**SSD-41579871 – Constellation Project – Lot: 4 DP751341 – Girilambone – TfNSW
response related to RTS**

Thank you for your correspondence requesting Transport for NSW (TfNSW) to review and comment on the above.

Figure 2: Intersection of the western side of Mitchell Highway and Railway Road

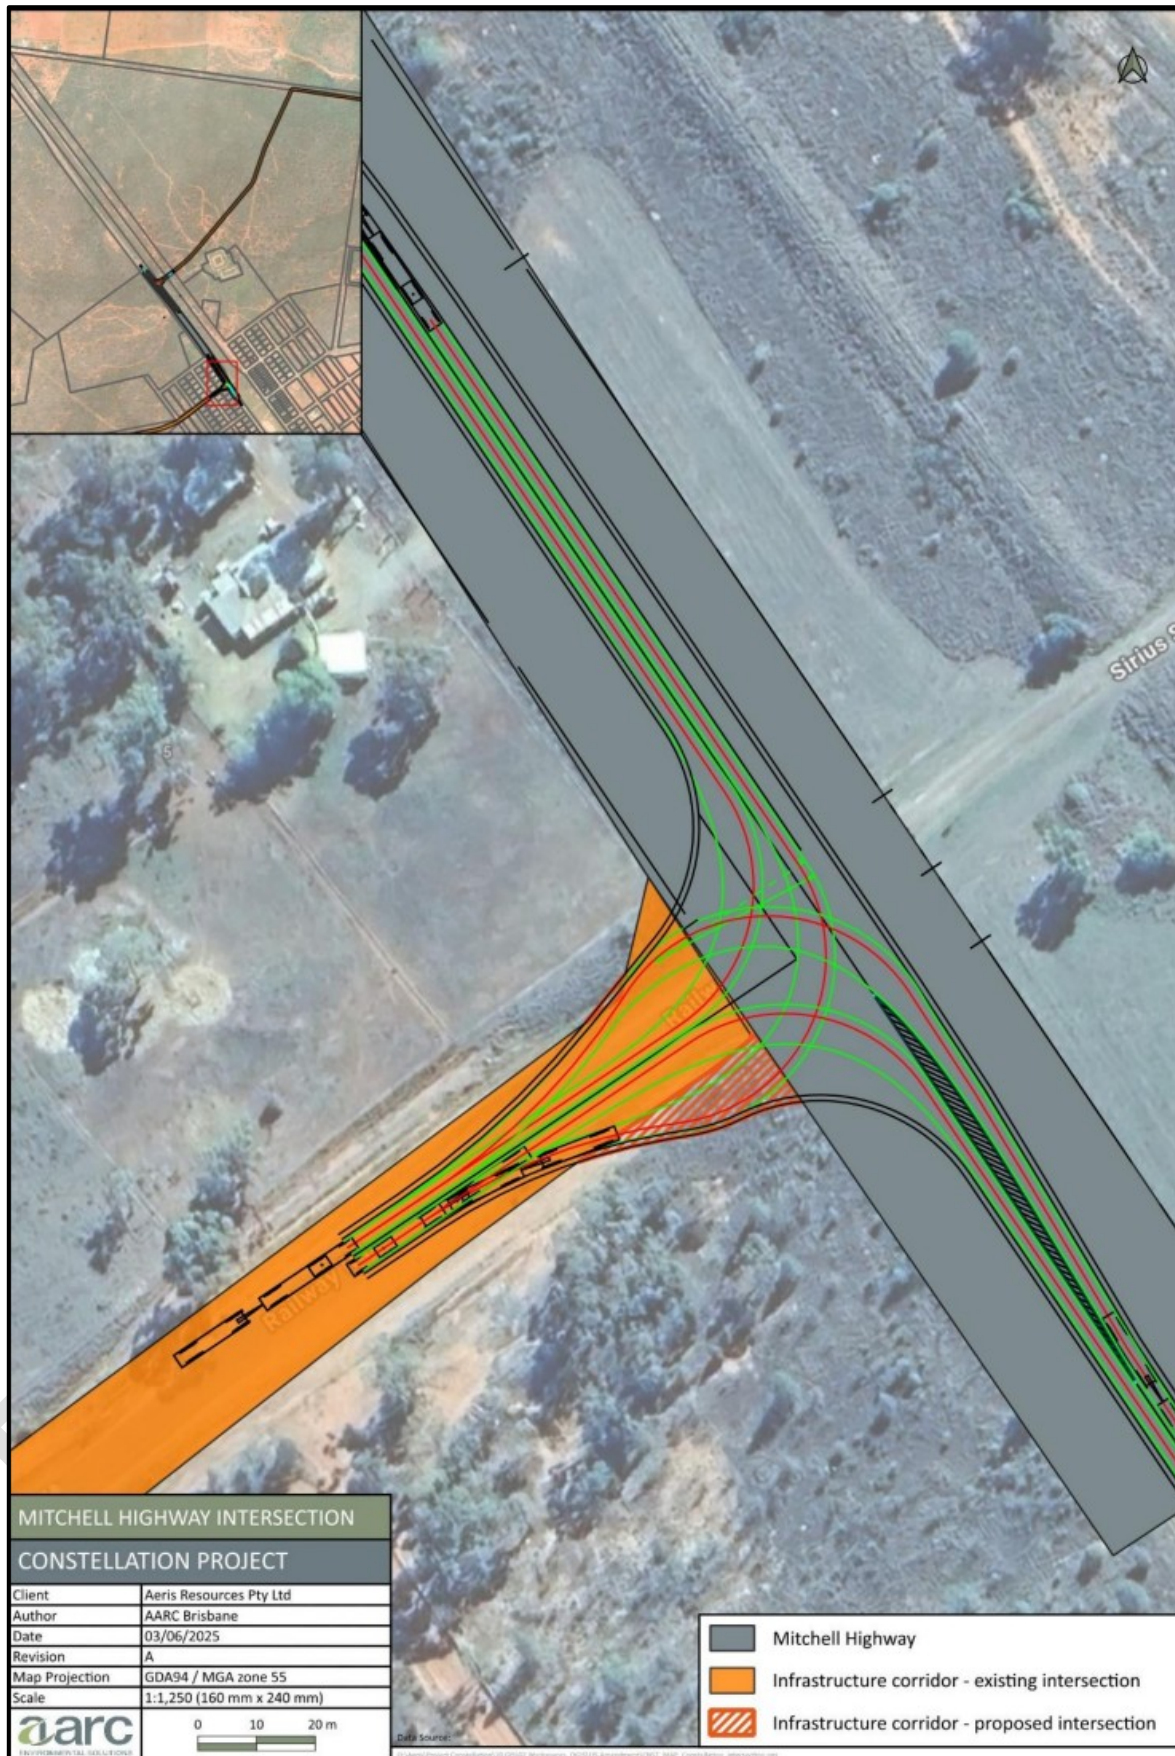
Aeris proposes that *maintenance associated with the level crossing in the UGLRL rail corridor, which is currently not operable, be included in the road use agreement with Bogan Shire Council.*

TfNSW objective is to ensure that the non-operational rail corridor is able to become operational with no significant additional safety risks or costs as a result of the development.

As such, the applicant needs to have licence agreement with UGLRL. The applicant needs to communicate with UGLRL third party Works for any such agreement

Aeris proposes *that stormwater maintenance interface boundaries associated with the*

access road over the railway corridor, and the proposed culvert treatment, be included into the road use agreement with Bogan Shire Council

There is to be no additional stormwater directed into the railway corridor as a result of proposed work. Stormwater drainage details will need to be provide to UGLRL during the application to the third party works team. This will be assessed with the application.

It is requested that the applicant be conditioned to contact UGLRL's third-party works team. UGLRL's team will assess the request and will recommend whether the access road be approved or not. If approved a licence agreement will need to be entered into for the crossing, prior to the issue of any construction certificate.

It is requested that the applicant be conditioned to contact UGLRL's third-party works team, who will assess the stormwater drainage as a part of the access road application prior to the granting of any licence for the works,prior to the issue of any construction certificate.
